STATE OF NORTH CAROLINA
DEPARTMENT OF TRANSPORTATION

Addendum No. 2

RE: Contract # C204107

Cumberland County (U-4405)

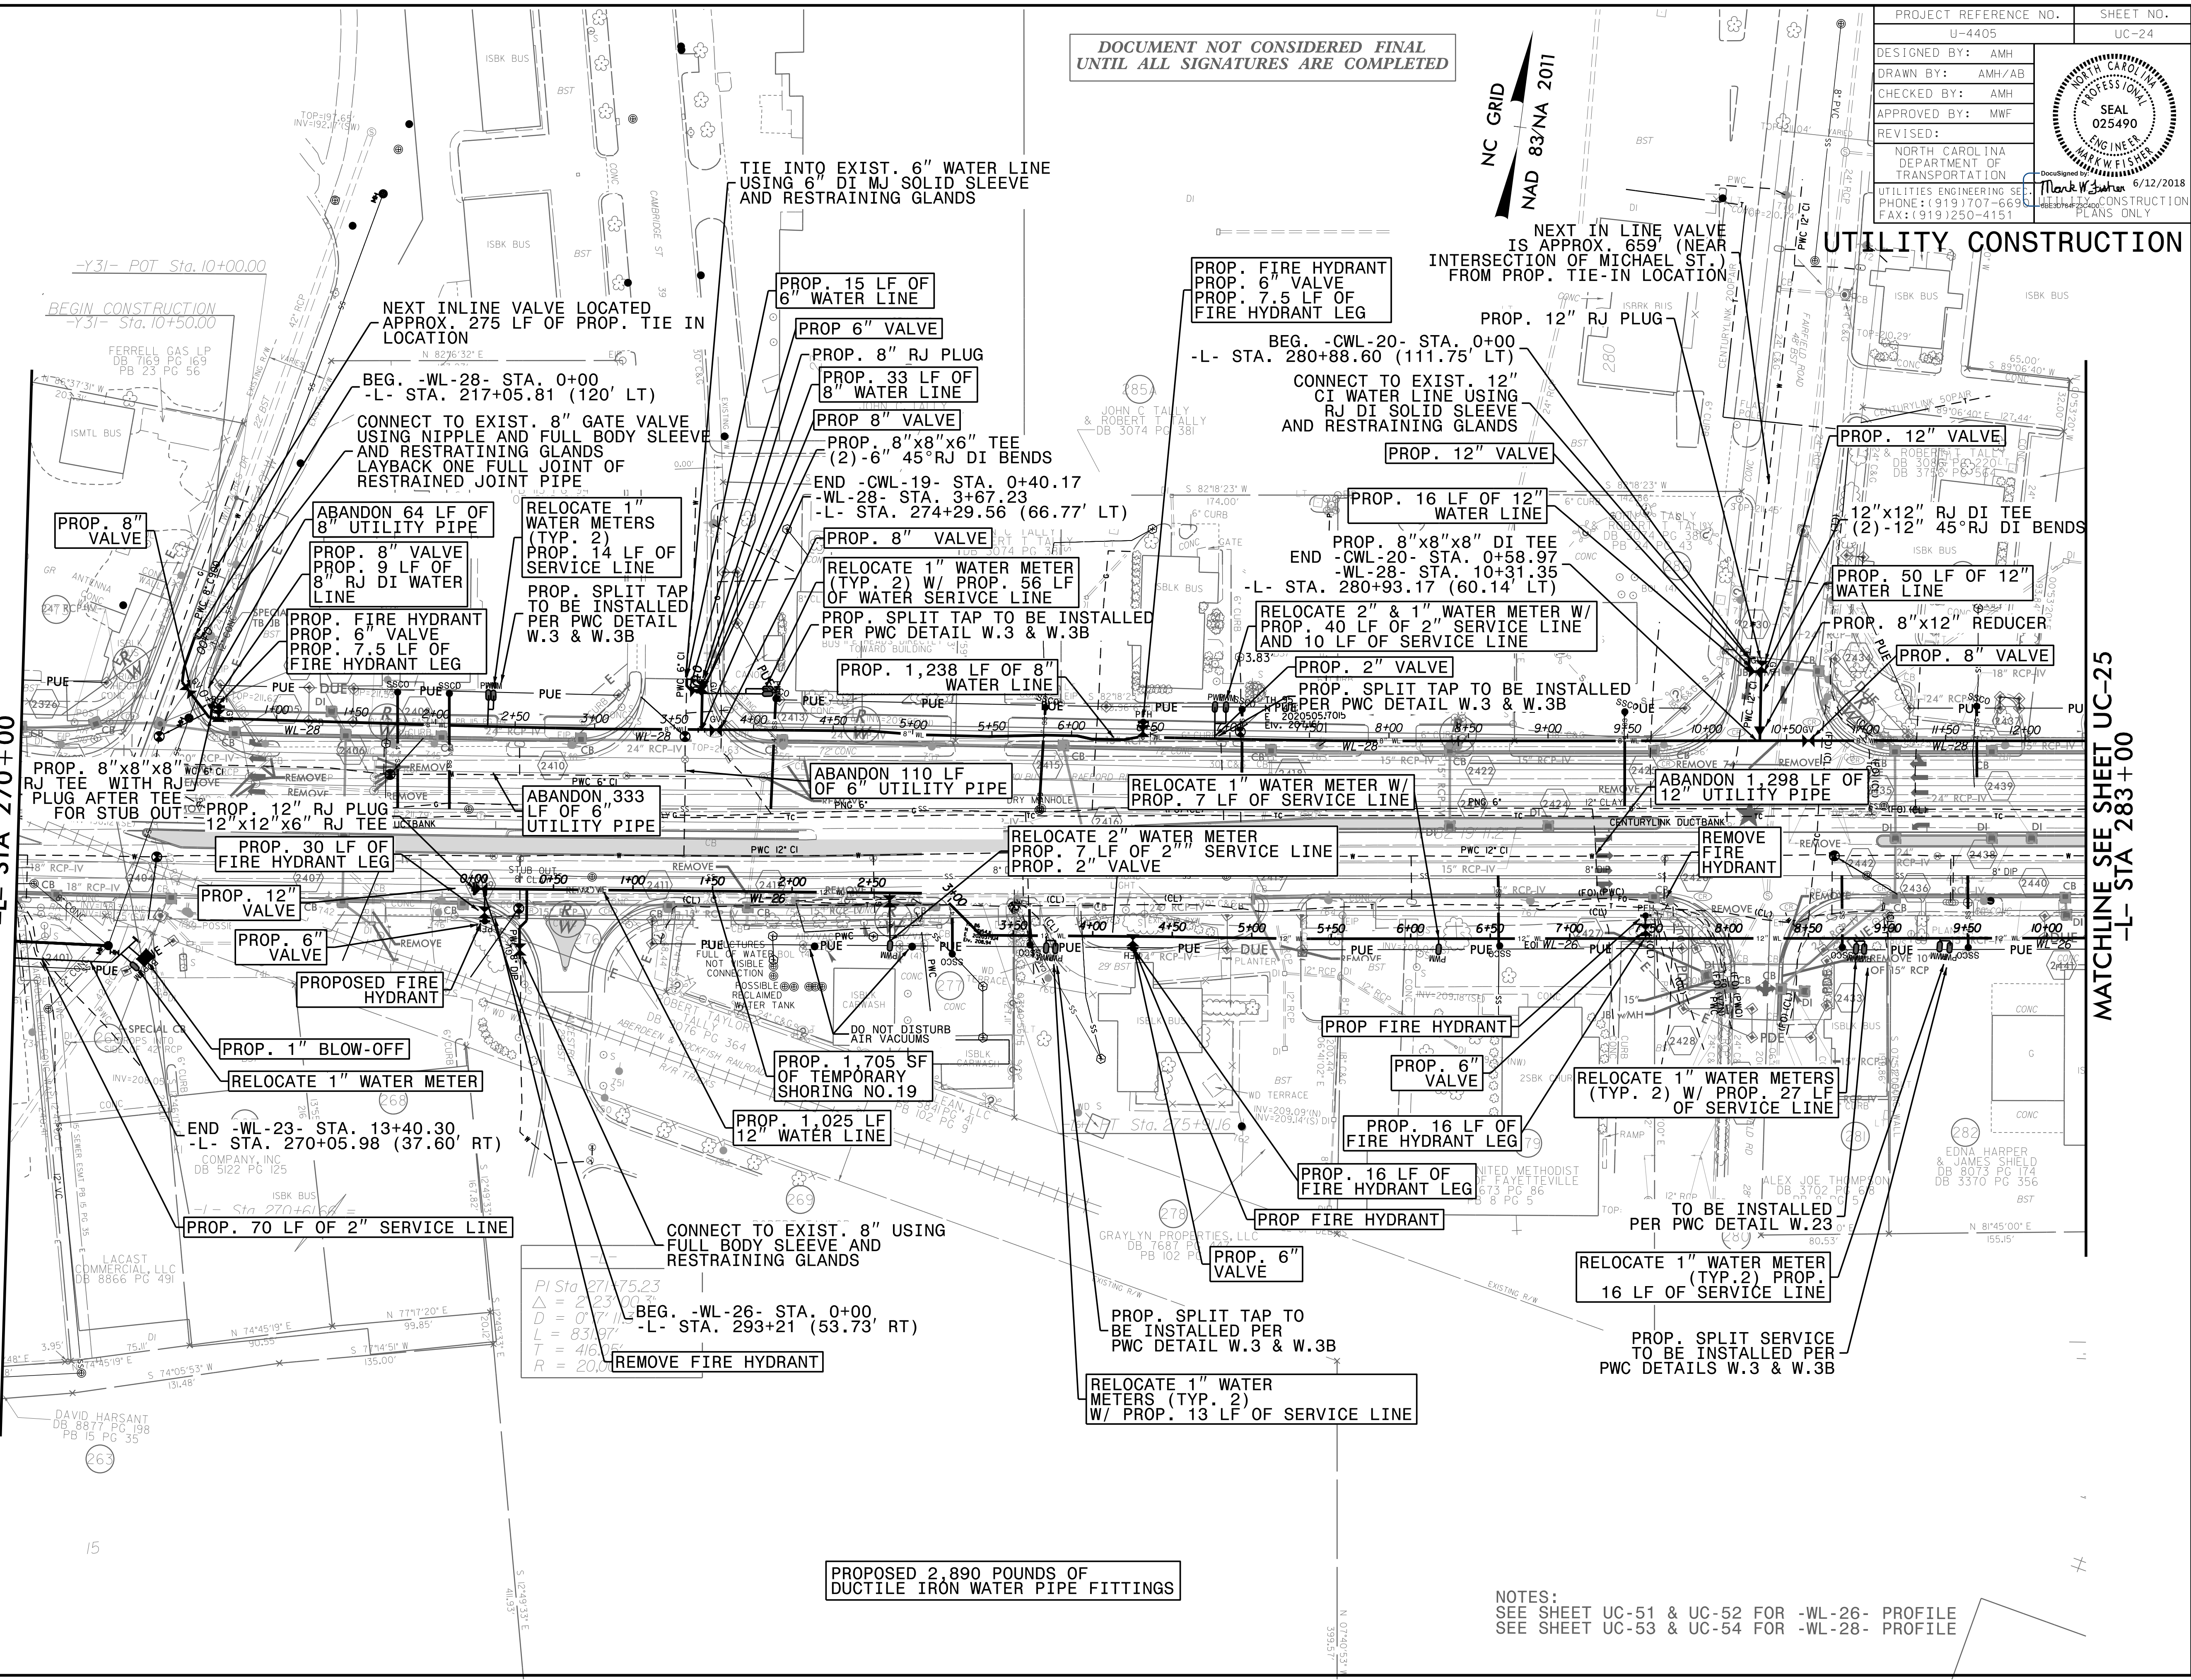
UC-23	Shifted valve on -WL-20R2- to Sta. 78+38.35; added killout symbol on Owen Drive; relocated valve from Owen Dr. to WL-23; revised proposed waterline type from 6" to 8" and added temporary shoring to Bore and Jack of 16" across McPherson Church Rd.
UC-23A	Added note to abandon 290 LF of 8" utility pipe
UC-24	Moved tie-in on Ancestry Drive out of the railroad ROW; added callout referencing next-in-line valve on Cambridge Street; revised callout for the length to nearest valve on Fairview Dr. to 760 LF
UC-25	Shifted two valves on WL-28 to Sta. 19+62.50 and Sta. 24+22.49
UC-26	Added an 8" valve to WL-28 at Sta. 27+21.85 and a 12" valve to WL-26 at Sta. 30+63.86
